REFUSAL OF PLANNING PERMISSION

APPLICATION NO. 2015/0639

Proposal Demolition of existing dwelling and erection of one pair of semi-detached dwellings (Resubmission)

At 38 Chapel Street, Hoyland, Barnsley, S74 0NW

Front Elevation
scale 1:100

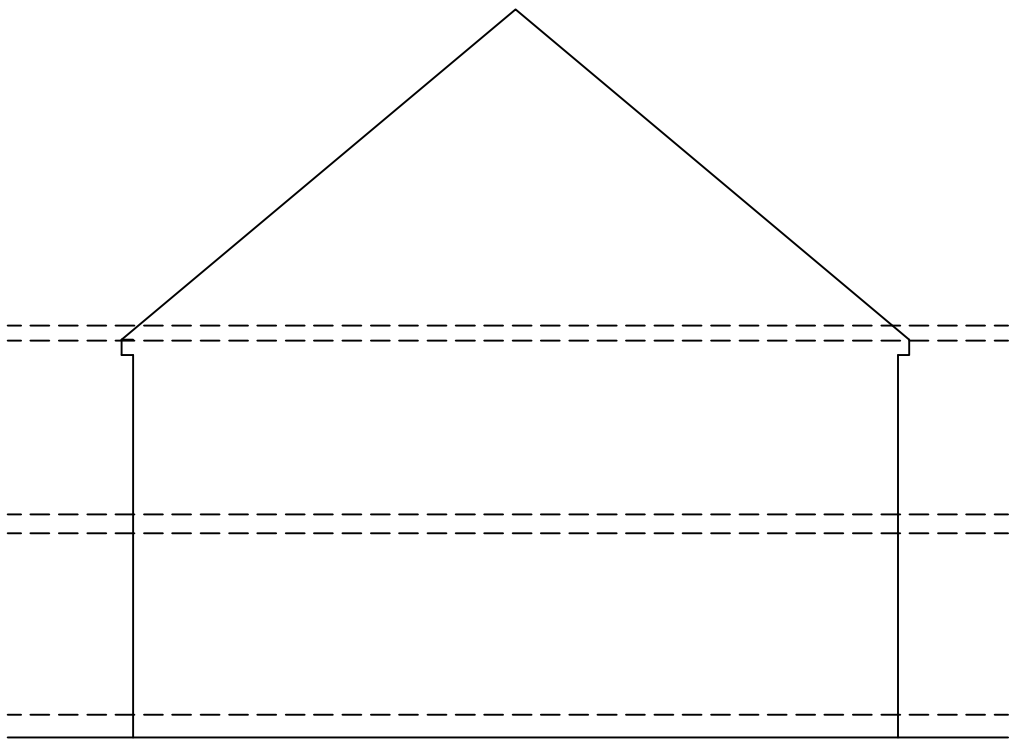
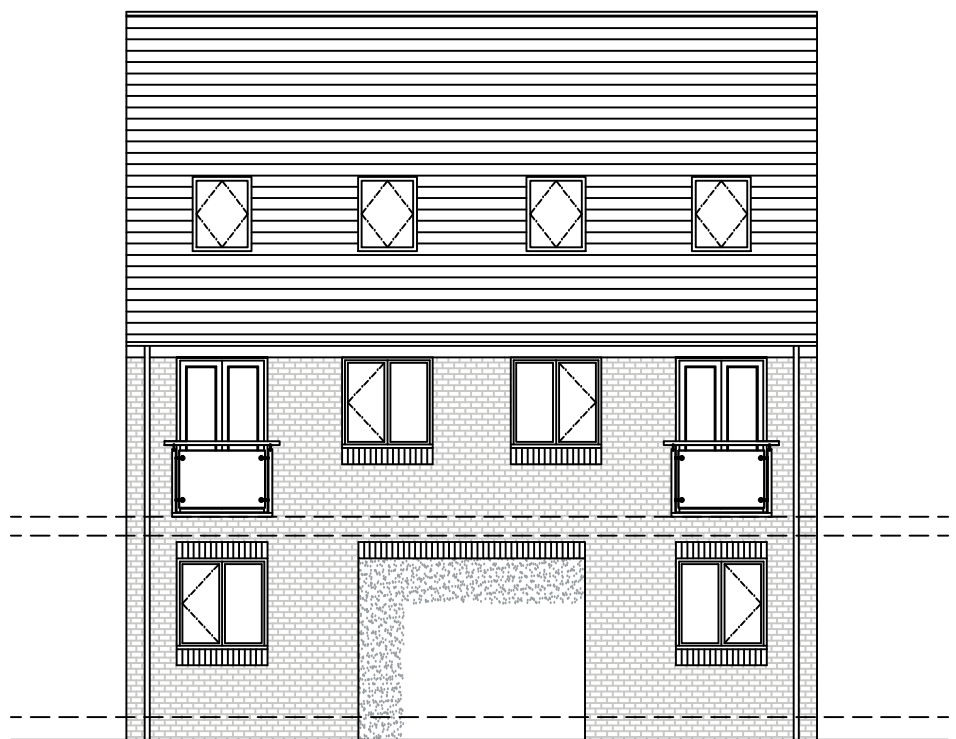
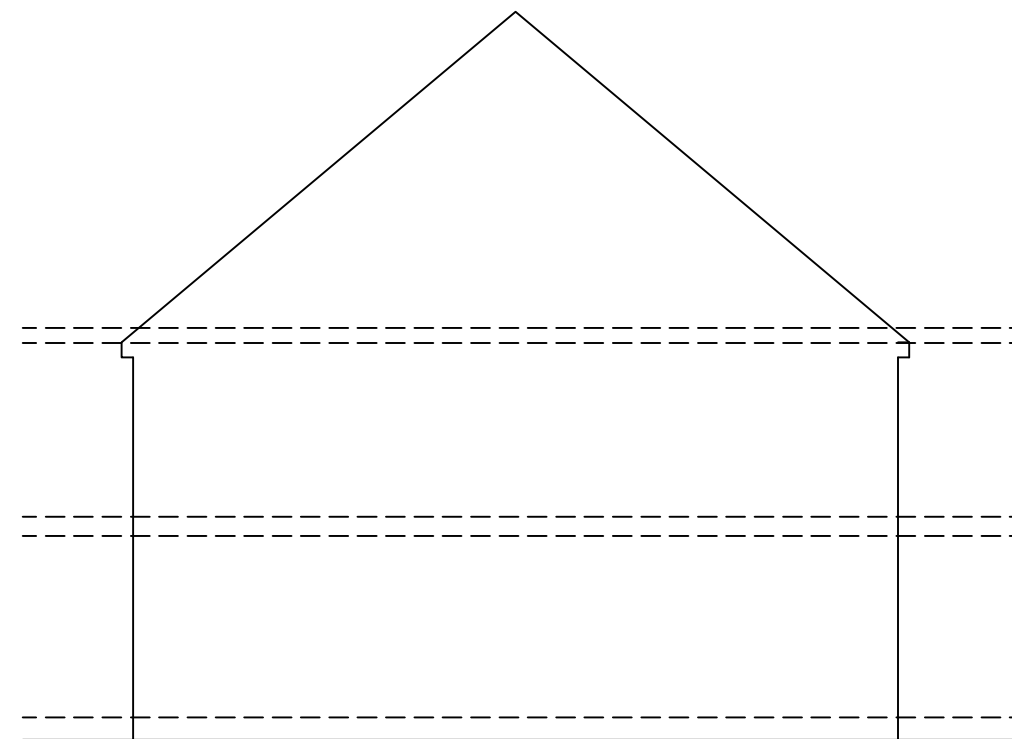
- 2 In the opinion of the Local Planning Authority, the design of the proposed properties, specifically the eaves and ridge heights, would be incongruous with the adjacent properties and as a result be detrimental to the character and appearance of the street scene and harmful to the local environment contrary to Core Strategy policy CSP29, Unitary Development Plan policies H8A and H8D, the relevant planning policy statements in the National Planning Policy Framework relating to requiring good design and the Supplementary Planning Document - Designing New Housing Development.

Proposed Ground Floor Plan
scale 1:50

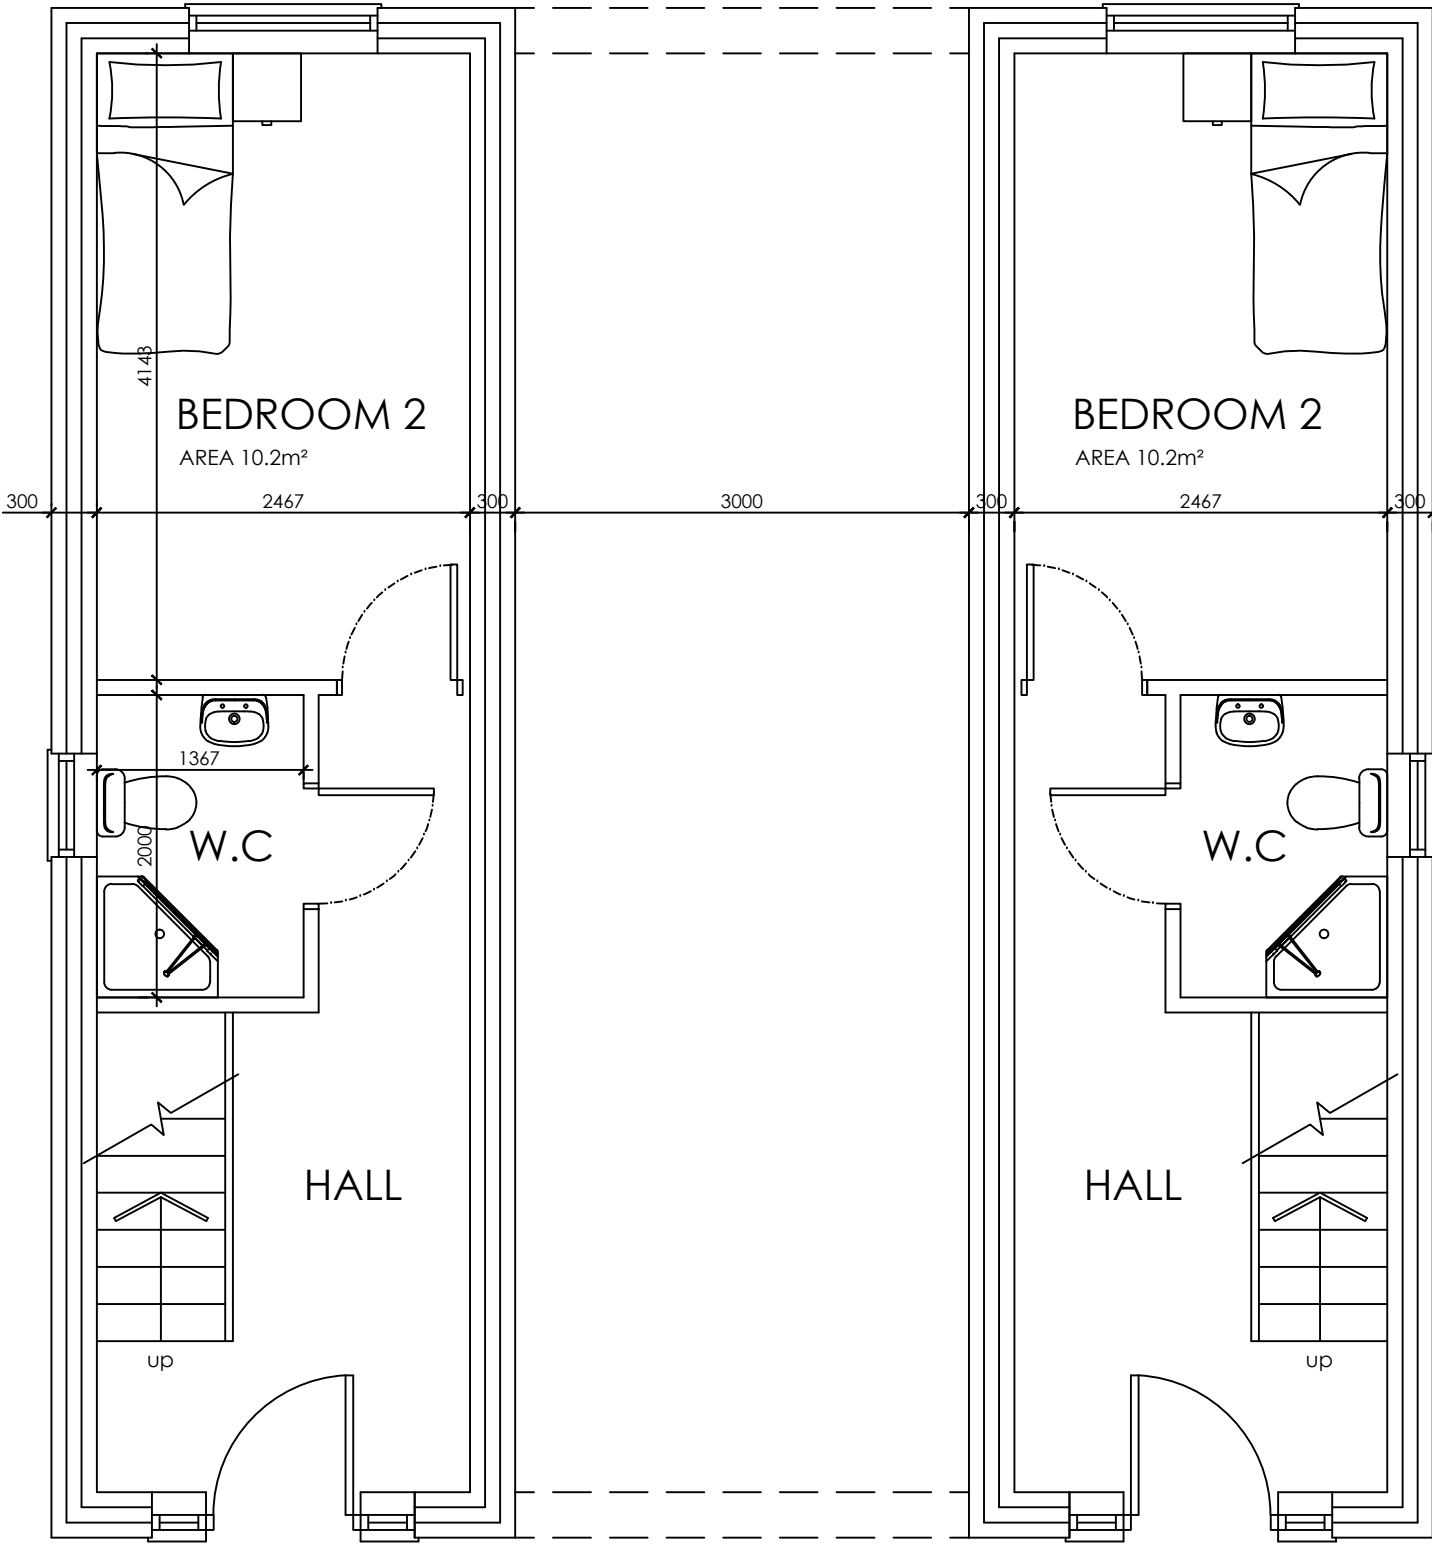
- 1 In the opinion of the Local Planning Authority, the occupants of the proposed dwellings would not be provided with a sufficient level of rear garden space, the proposal falling well short of the 50 square metre standard required by the adopted Supplementary Planning Document: Designing New Housing Development. As such, the proposed development is also contrary to Core Strategy policy CSP29 and Unitary Development Plan policy H8A, and the fourth core principle in the National Planning Policy Framework and planning policy statements relating to requiring good design, which require high quality design and good standards of amenity for the future occupants of buildings.

- 3 In the opinion of the Local Planning Authority, the proposed off-street parking layout does not allow for convenient vehicular manoeuvring, which is likely to result in on-street parking or vehicles reversing to and from the highway to the detriment of the free and safe flow of traffic on the highway, contrary to Core Strategy policy CSP26 and Unitary Development Plan policies H8A and H8D.
